Our reference: DOC14/237645-03 EF14/23995
Contact: Natasha Ryan 02 49086833
Electronic correspondence to: Hunter.region@epa.nsw.gov.au

**CENTENNIAL NORTHERN COAL LOGISTICS PROJECT SSD 5145
RECOMMENDED CONDITIONS OF APPROVAL - NOISE**

**ENVIRONMENT PROTECTION AUTHORITY – REVIEW OF ENVIRONMENTAL ASSESSMENT AND
RECOMMENDED CONDITIONS OF APPROVAL - NOISE
SSD 5145
CENTENNIAL NORTHERN COAL LOGISTICS PROJECT**

Figure 1: NCSS - Noise Receiver Locations

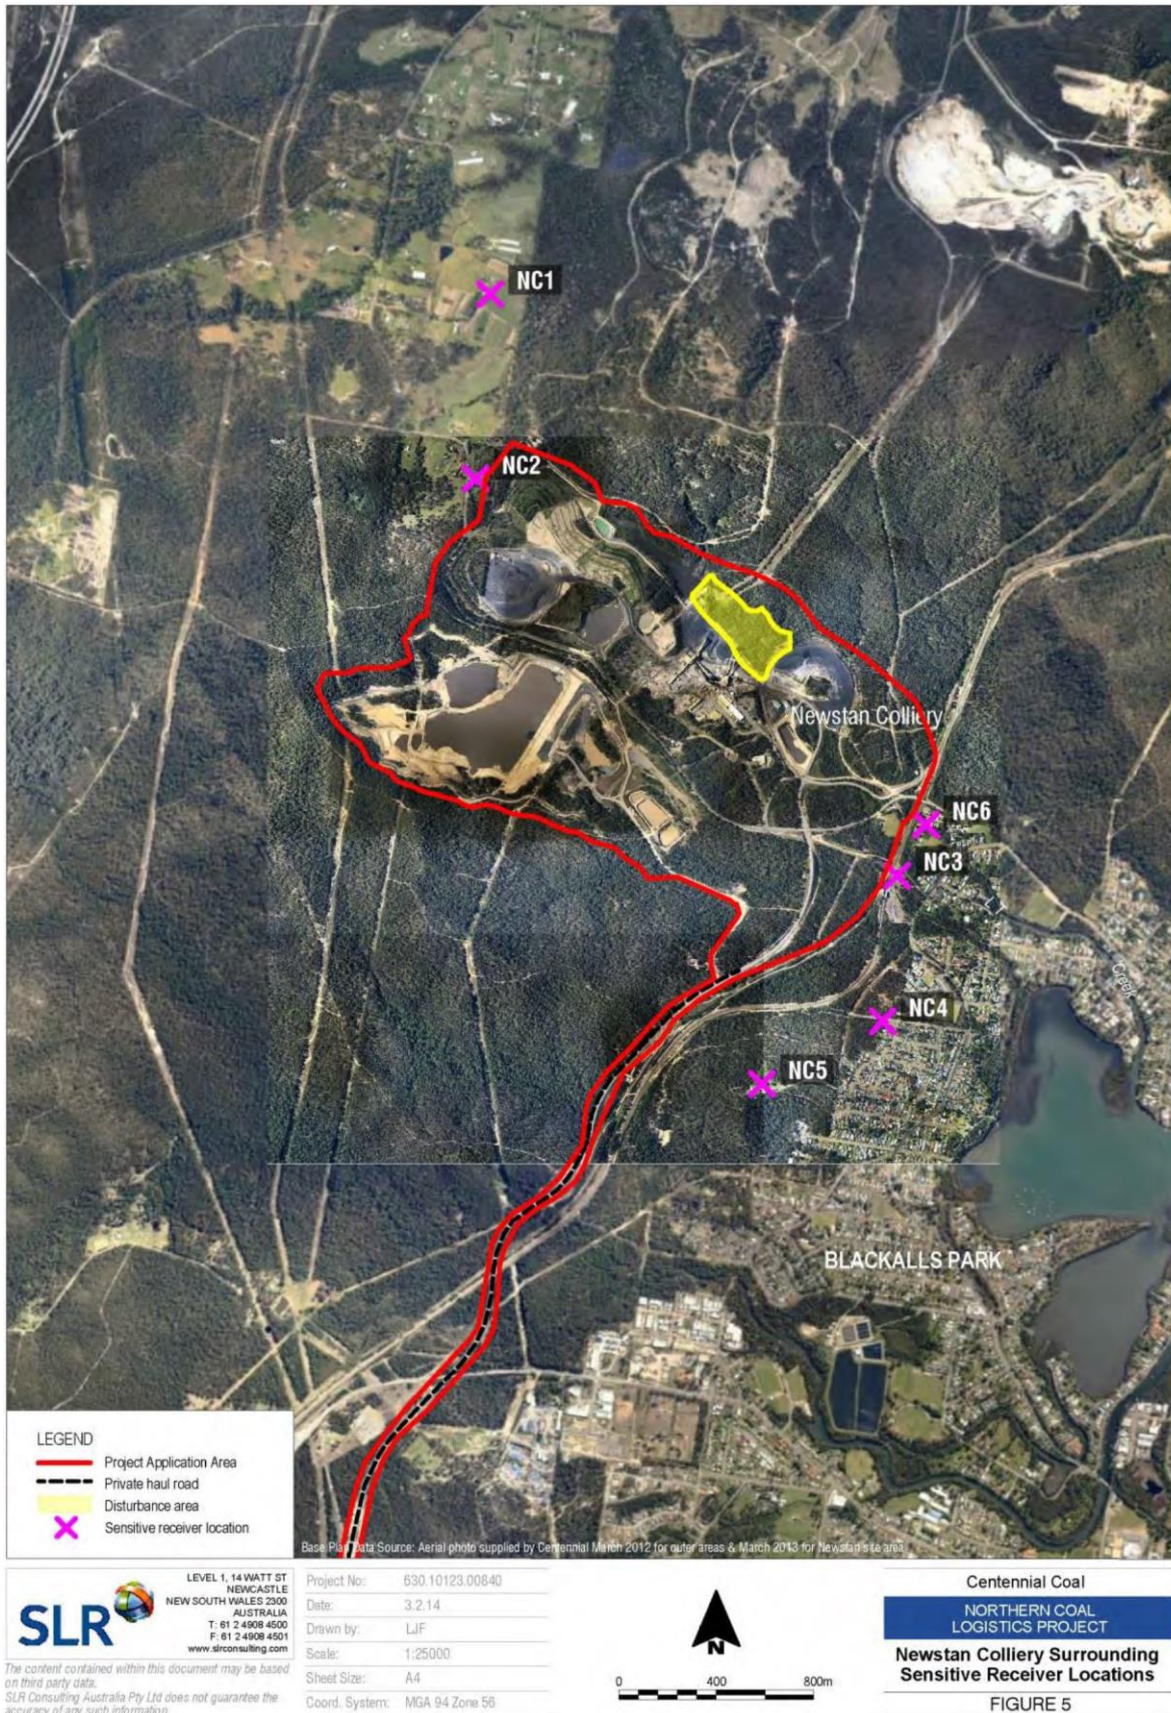
2. Model results for comparison against PSNLs for the nearest residential sensitive receiver in the vicinity of receiver NC6 (a primary school). From the information in the NVIA, the EPA expects that the PSNLs for receiver locations NC3 and NC5 may also be suitable for the residential receiver locations near NC6; and
3. For any noise impacts above the relevant PSNLs, justification that:
 - a. The noise levels predicted are those that result after the implementation of all feasible and reasonable noise mitigation measures; and
 - b. The noise mitigation measures committed to the project are all that are feasible and reasonable for it to implement.

The EPA expects, based on the information presented in the NVIA for scenarios 1 to 4, that the project will exceed night time PSNLs by up to 1dBA at receiver location NC4, up to 5dBA at receiver location NC3, and by up to 7 dBA at residential receiver locations near NC6 during the morning shoulder period. If the new coal processing and preparation plant (CPP) is built using noise attenuating cladding, the EPA expects PSNLs will still be exceeded by up to 2 dBA during the night time at receiver location NC3, and by up to 4 dBA at residential receivers near NC6.

NC4 by up to 1 dBA during the night time. NC3 and NC4 are at the edge of residential areas so it is likely that a number of residential receivers will be affected by the project to a similar extent. The maximum L_{eq} levels of the project provided by the NVIA is summarised in **Table 3**.

- a. Exceeds the PSNL at NC4 by up to 1 dBA, and at NC3 by up to 5 dBA.
- Modelled noise levels as a result of the project at residential sensitive receivers near NC6 (a school) were not presented in the NVIA. Daytime $L_{eq(1hour)}$ predictions in the NVIA for receiver NC6 were typically 2 dBA above the corresponding $L_{eq(15min)}$ predictions for receiver NC3, which is located in a similar location relative to the project. This indicates that residential receivers near receiver NC6 may be impacted by the project by between 3 and 7 dBA above PSNLs.
